Please ask for: Nicola Moore
Email: nicola.moore@arun.gov.uk
Telephone: Ext 37944
Our Ref: BR/31/22/PDH
Your Ref:
Date: 18th February 2022

Prior Notification for a Permitted Development (Householder)

Development: Notification under extended permitted development rights for a single storey rear extension measuring 4m from beyond the rear wall of the original dwelling house, with maximum height of 3m and eaves height of 2.50m.
Location: 26 Gibson Way Bognor Regis PO21 1AW

Proposed Ground Floor Plan

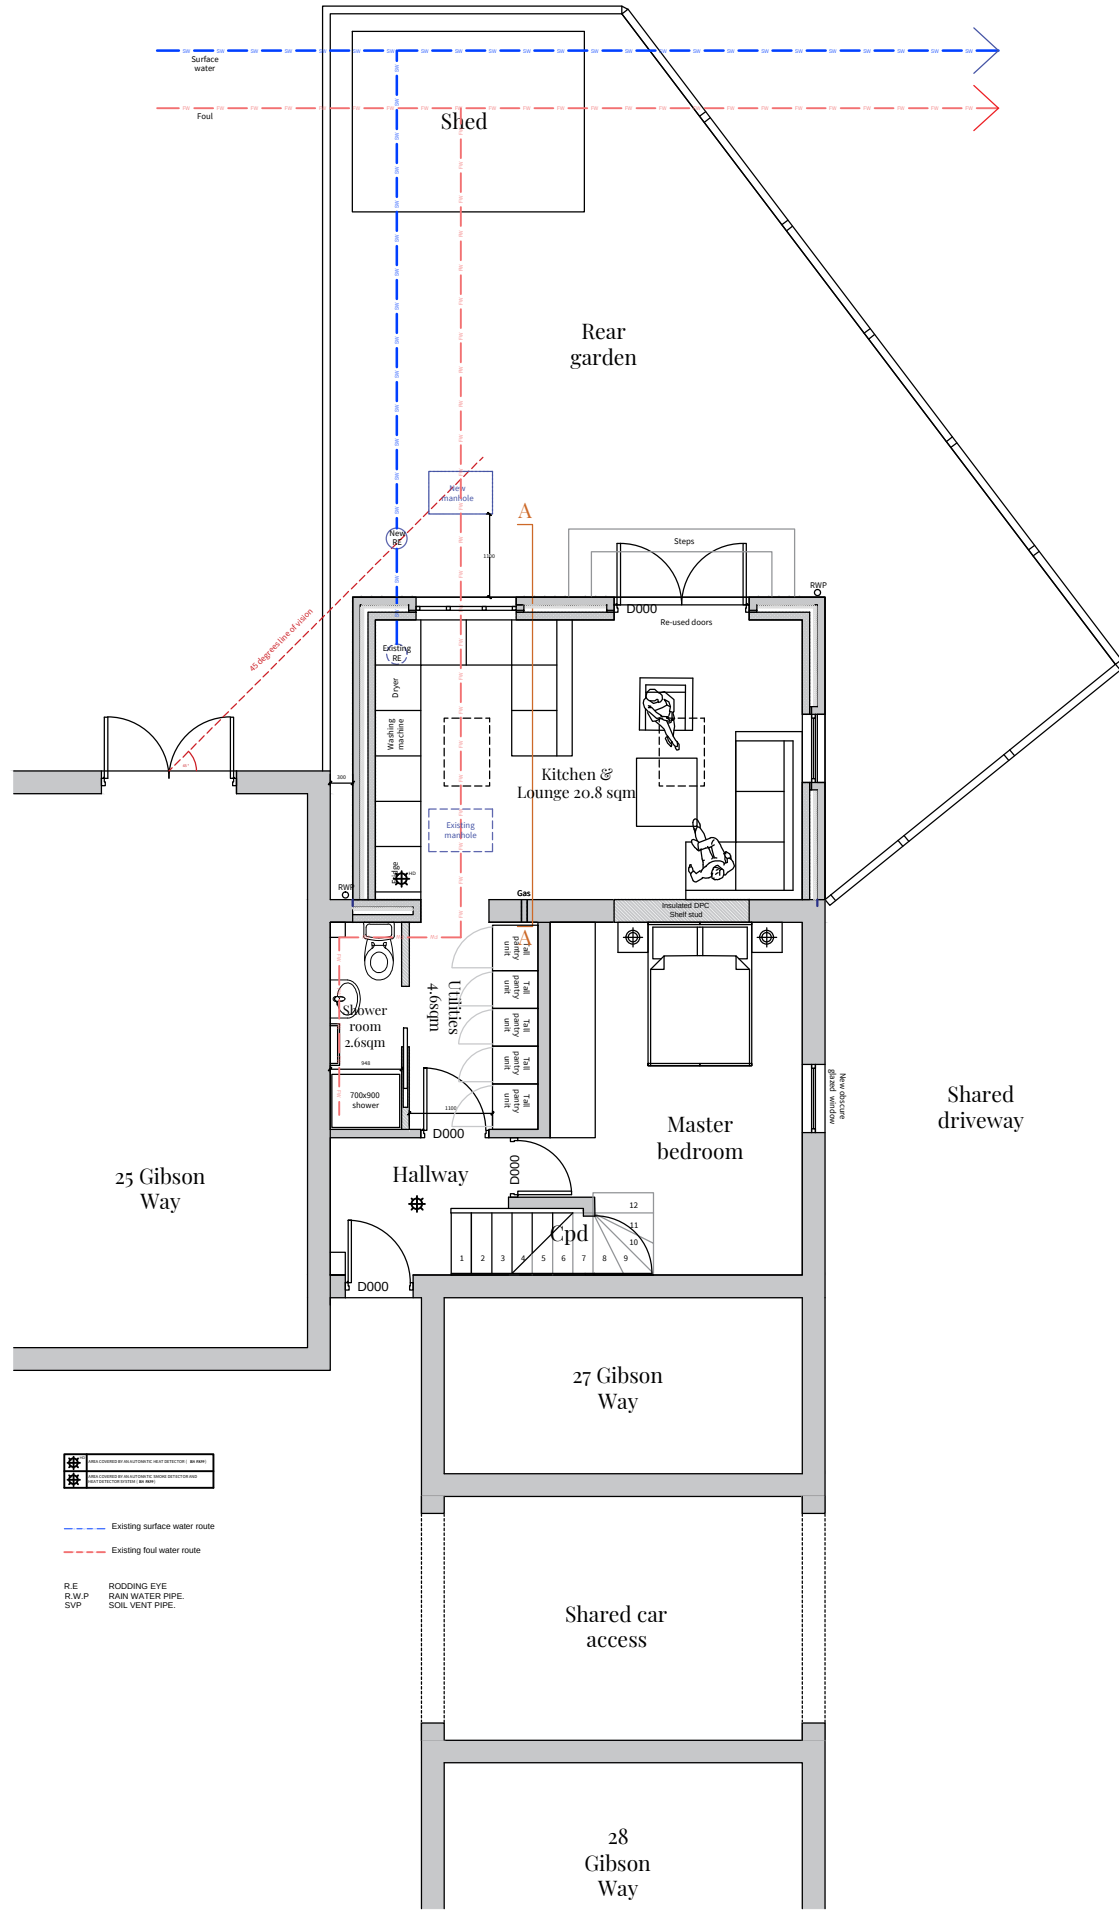
The window on the proposed South East elevation measures 1.2m, but on the proposed Floor Plan and Building Control Plan measures 0.8m. Please amend accordingly and re submit.
